The Drovers Solar Farm

Statement of Common Ground (SoCG) with Environment Agency (Clean)

Document reference: APP/5.13.2 (Revision 2)

DRAWING TITLE:
Figure 12.14: Work No. 3 Maximum Potential Foundations and Groundwater Elevations

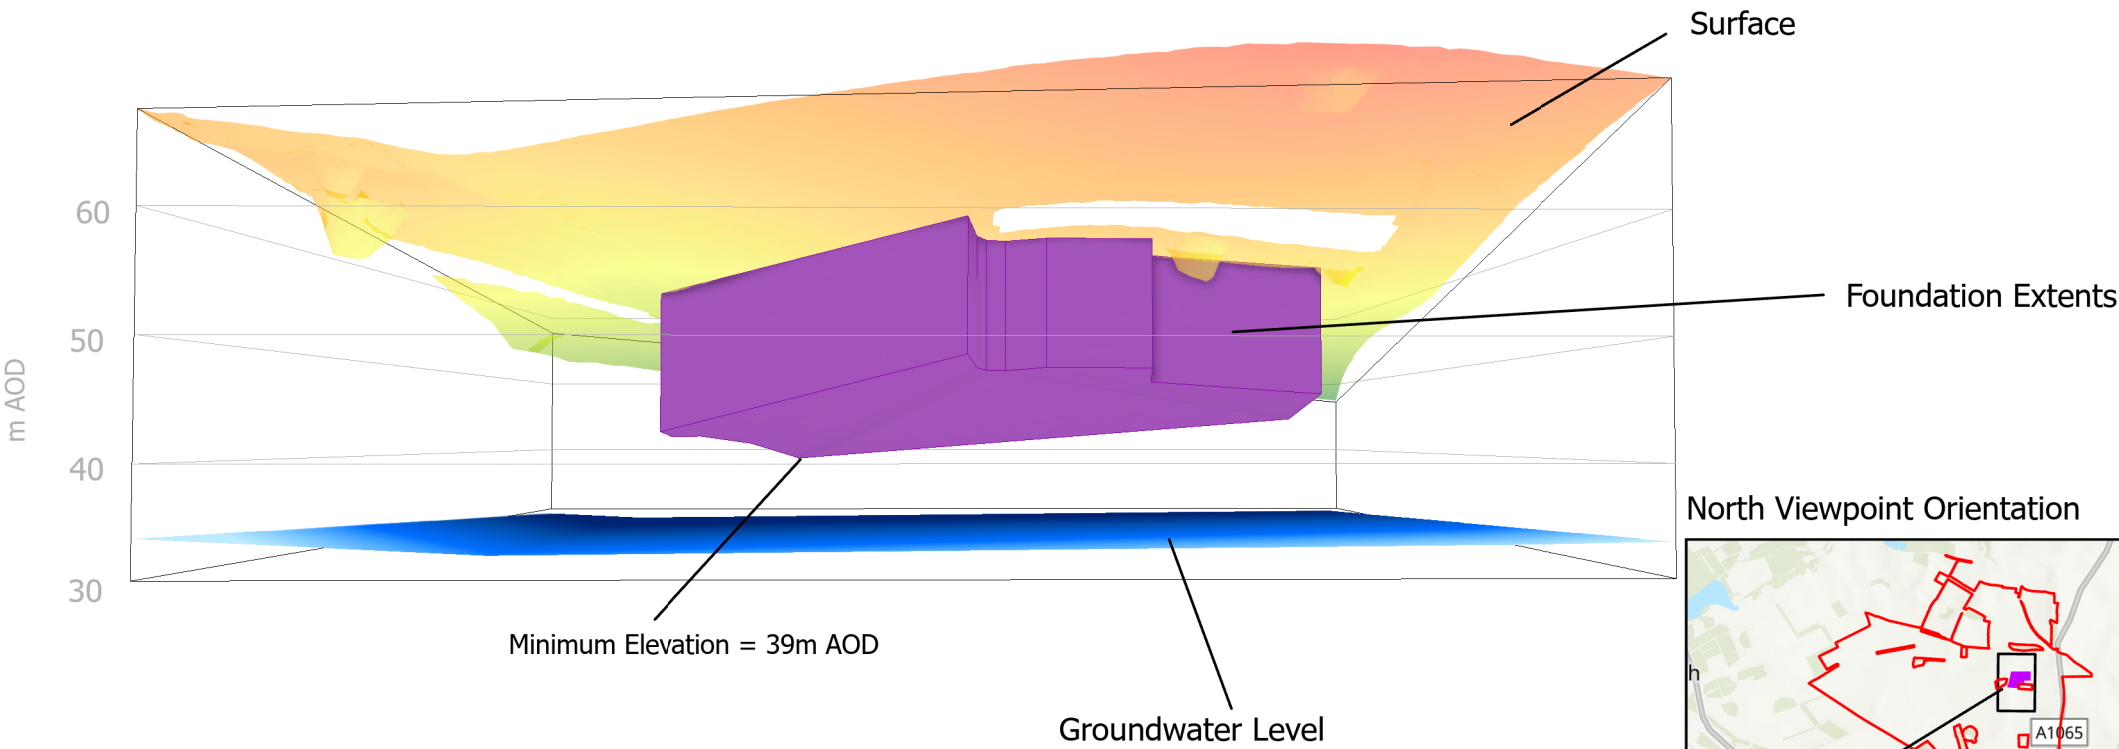
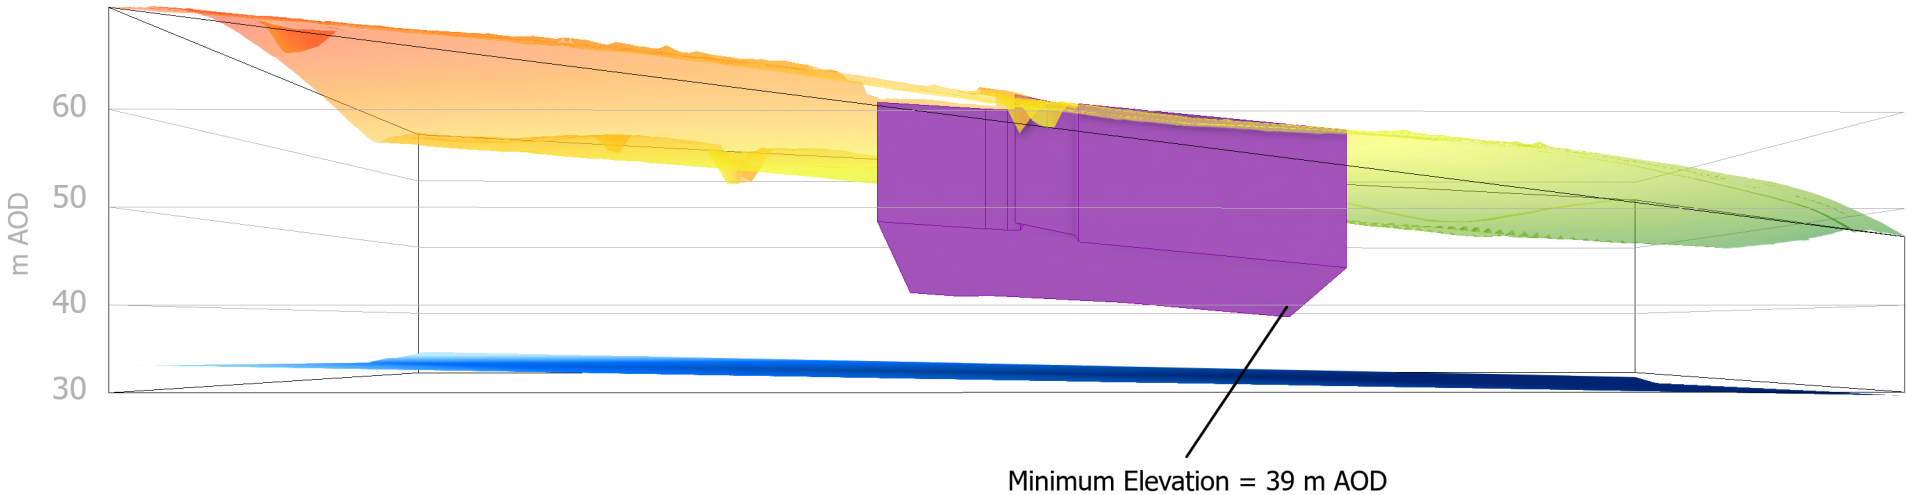
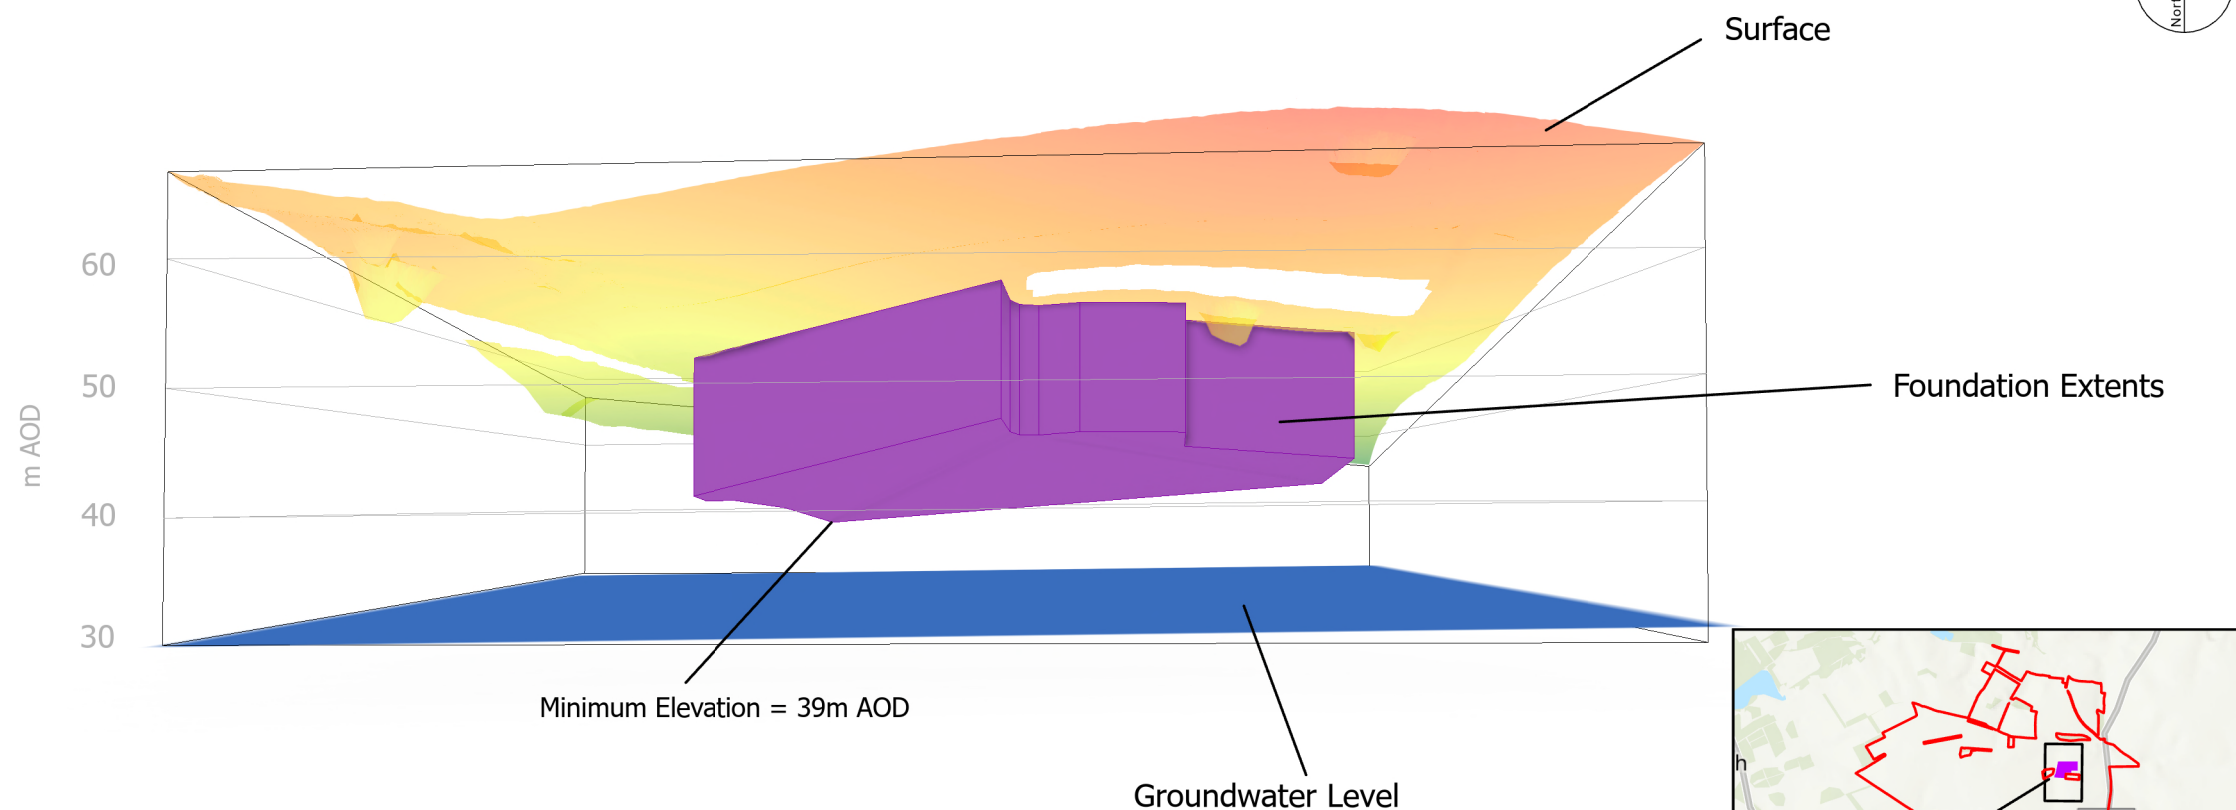
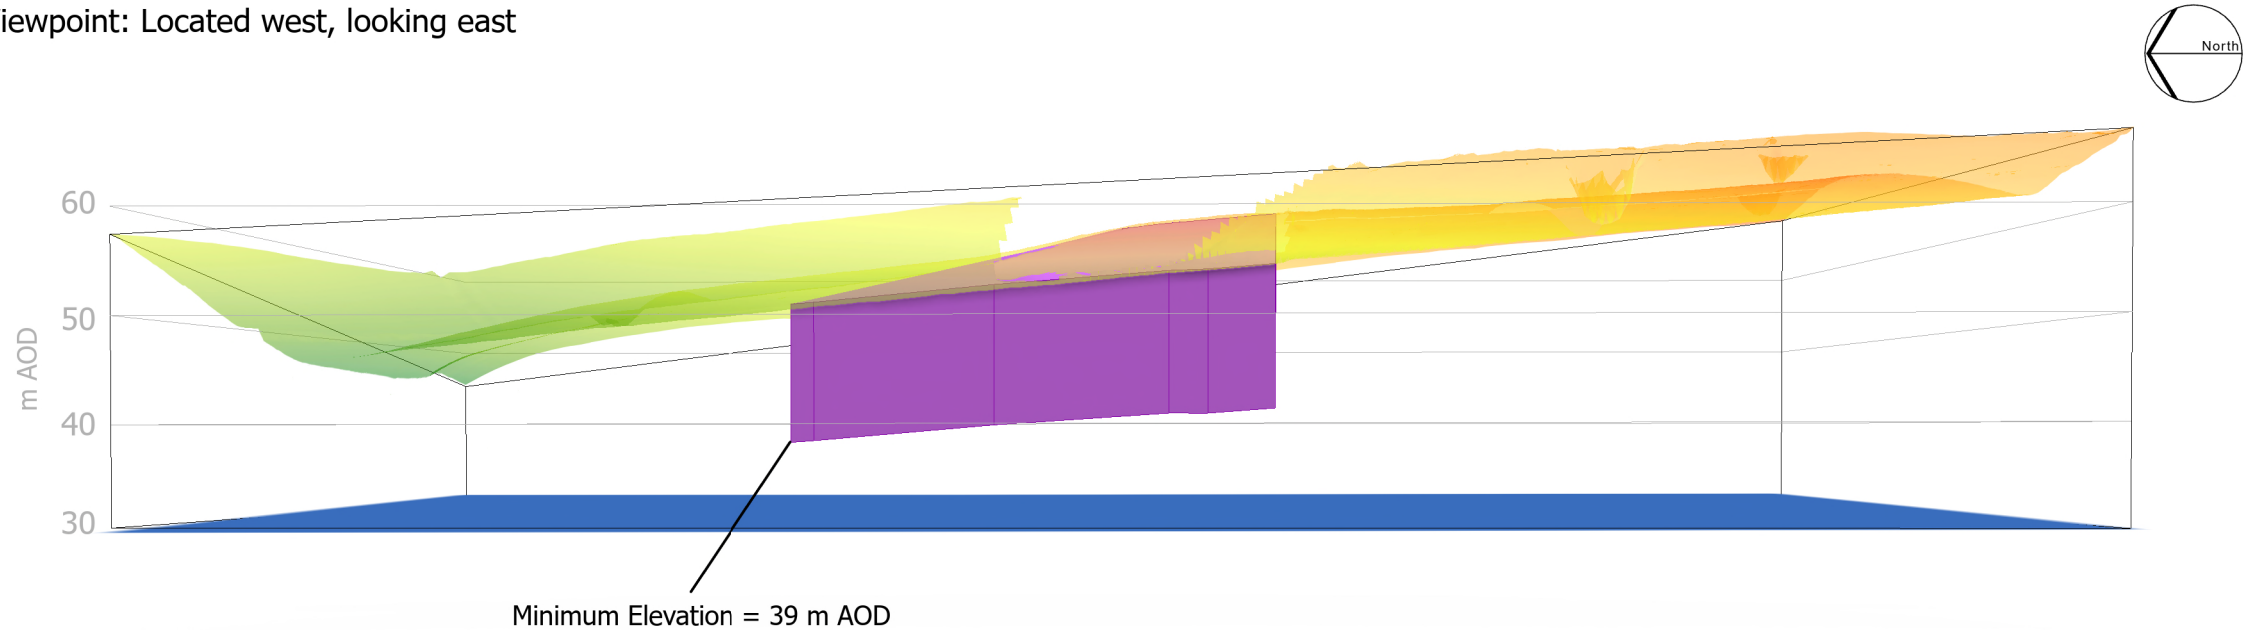
Reference	EA Issue Reference	Topic	Consultee's Position	Applicant's Position	Status
2-1	EA05	Maximum Foundation Extents	We are satisfied and consider this issue resolved. We were concerned that figures 12.13 [APP-127], 12.14 [APP-128], 12.15 [APP-129] and 12.16 [APP-130] do not clearly define the area represented by the drawings, including view orientation, or the elevation values. We have reviewed the following:	Figures 12.13 to 12.16 of ES Chapter 12: Water Resources [APP/6.2.3] were used to illustrate the maximum groundwater elevation surface across the Core Study Area and identify where proposed foundation depths could theoretically intercept shallow groundwater under worst-case conditions. The figures also demonstrate at a concept level where piling may be required depending on foundation design.	Agreed

• 6.3.1 ES Figure 12.13 Work No. 2 Maximum Potential Foundations and Groundwater Elevation [REP3-043] • 6.3.1 ES Figure 12.14 Work No. 3 Maximum Potential Foundations and Groundwater Elevation [REP3-044] • 6.3.1 ES Figure 12.15 Work No. 4 Maximum Potential Foundations and Groundwater Elevation [REP3-045] We find the updated figures satisfactory for defining the 3D model view, and elevation the maximum extent of the foundations	The following changes were made at Deadline 3 to aid the EA's interpretation: • Addition of orientation labels or description • Elevation shading to show mAOD values for the maximum groundwater elevation surface and foundation extent surface • Highlight areas where foundations intersect or exceed groundwater elevation surfaces; and • Figures and text refer to groundwater elevation (mAOD) rather than groundwater level to increase clarity between absolute elevation and depth below ground. The Applicant agrees that the conceptual model present is not the final tool for foundation design, but rather to provide a screening-level assessment of groundwater conditions and to identify areas needing piled or shallow foundations and will be aligned with EA regional groundwater understanding (NEAC model). The Design Principles, Parameters Commitments [APP/5.8.4] was updated at Deadline 2 to commit to foundations not directly interacting with groundwater. The Applicant maintains the position that a potential interaction of up to 1 m has been
